Harnett County Government Complex
307 W. Cornelius Harnett Boulevard
Lillington, NC 27546

**Re: Status of Improvement Permit Application #1807-0040
Gregory Circle**

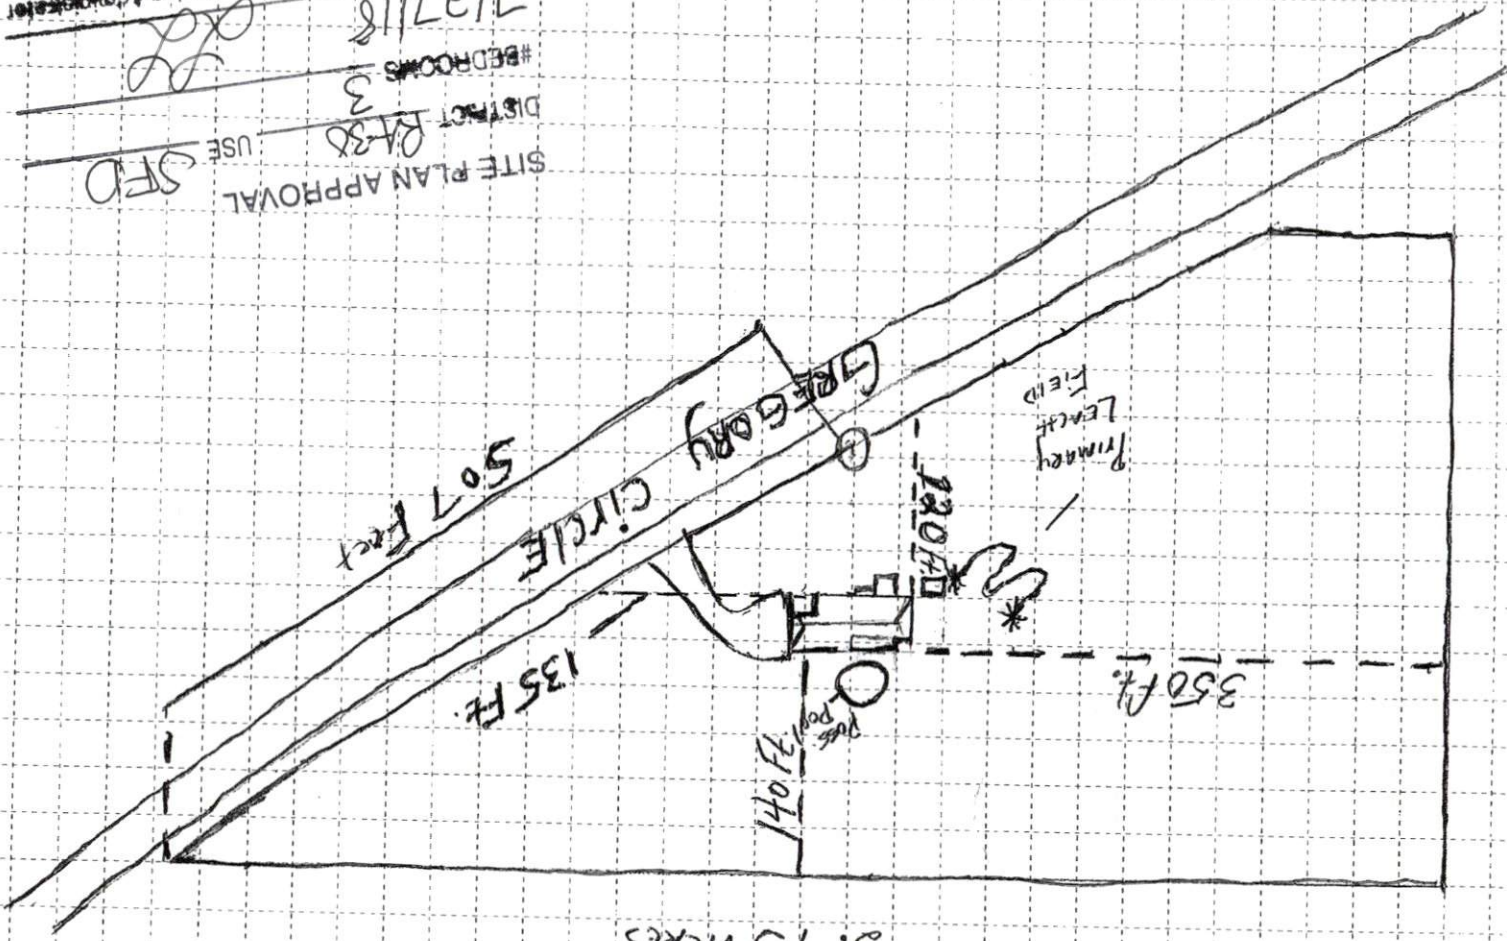
- 1. Use pink flags to mark property lines and irons that are set by surveyor need to be visible (*\$25.00 fee incurred*)
- 2. Use orange flags to mark house corners (*\$25.00 fee incurred*)
- 3. Directions not clear to property (*\$25.00 fee incurred*)
- 4. Property needs only brush or vegetation removed
- 5. Driveway not shown on site plan
- 6. Backhoe pits required
- 7. Other – Revision required to show front setback per Andrew Currin. Revise your application at Central Permitting.**

*INACCURATE FRONT
SETBACK*
